COUNTY COUNCIL'S RESPONSE TO CONSULTATION ON THE FOLLOWING DEVELOPMENT PROPOSAL

Application no:19/01036/F

Proposal: Development of a new Local Centre comprising Retail, Commercial and Community floorspace (flexible Use Class A1/A2/A3/B1/D1), and 38 residential units (use class C3) with associated access, servicing, landscaping and parking

Location: Bicester Eco Town Exemplar Site Phase 2 Charlotte Avenue Bicester

Appendix E - Drainage Strategy

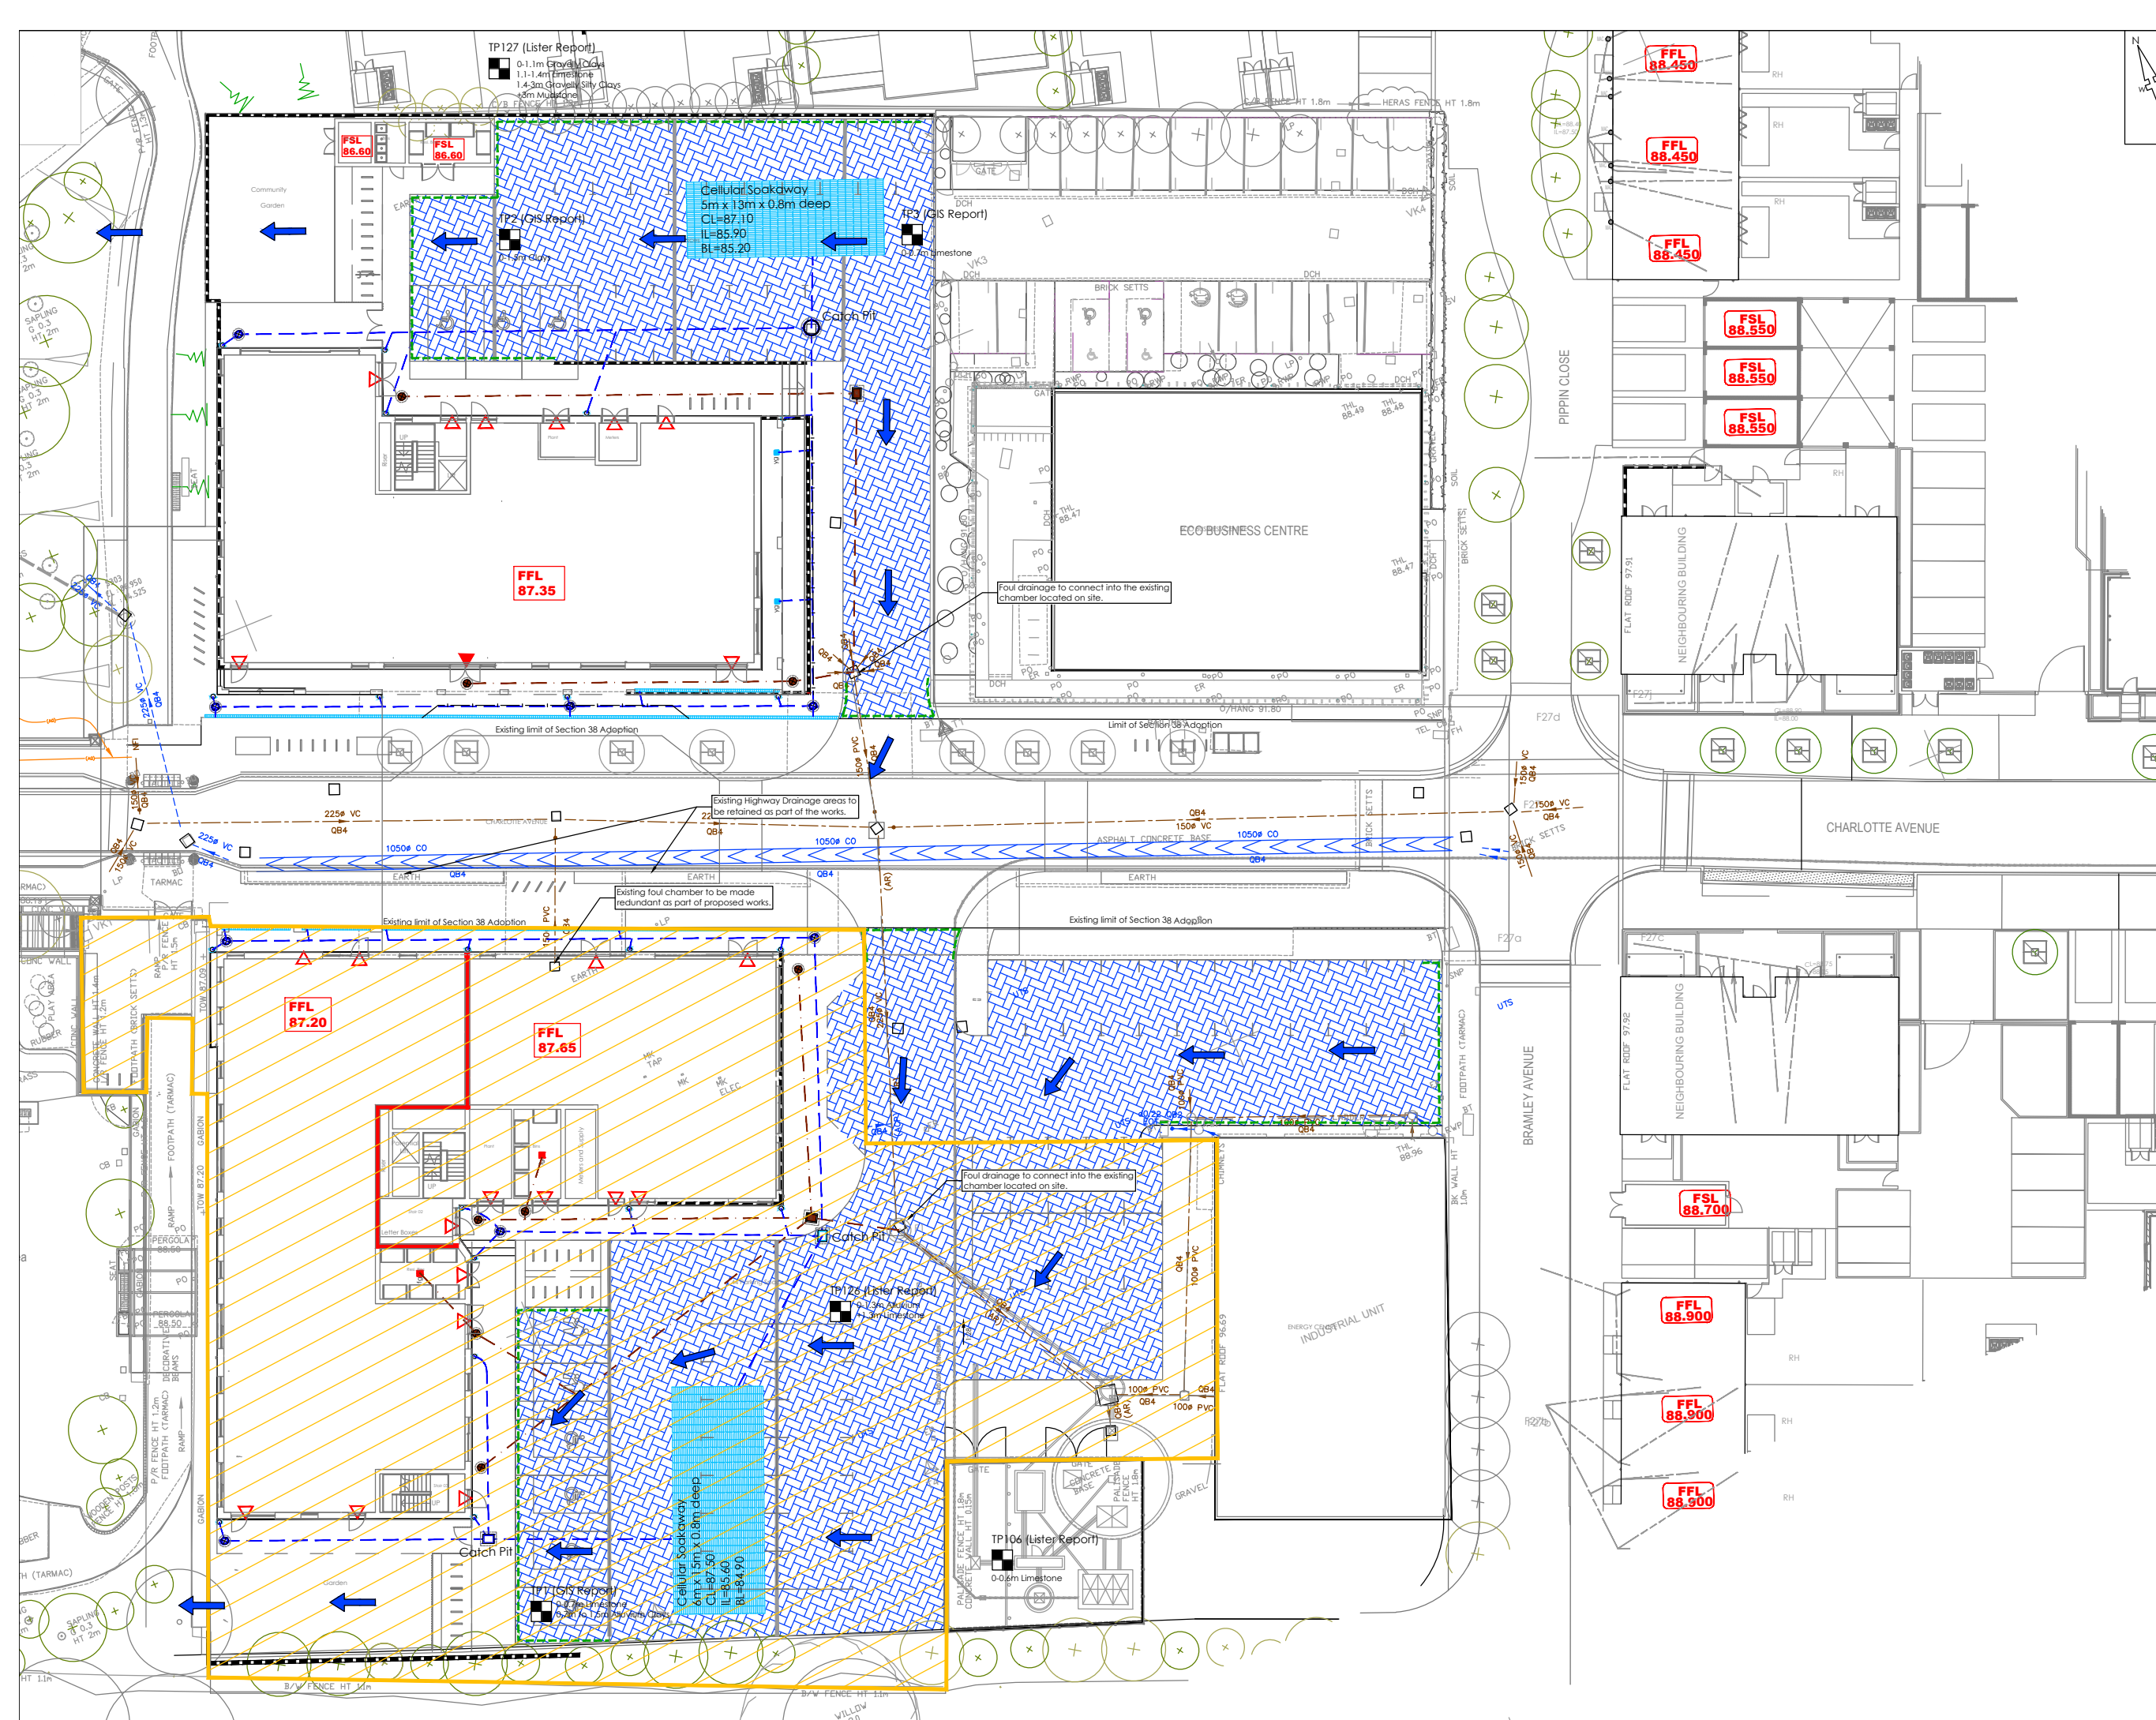
DWG TP-01 Rev 2 states infiltration to be undertaken but no further evidence appears to have been provided.
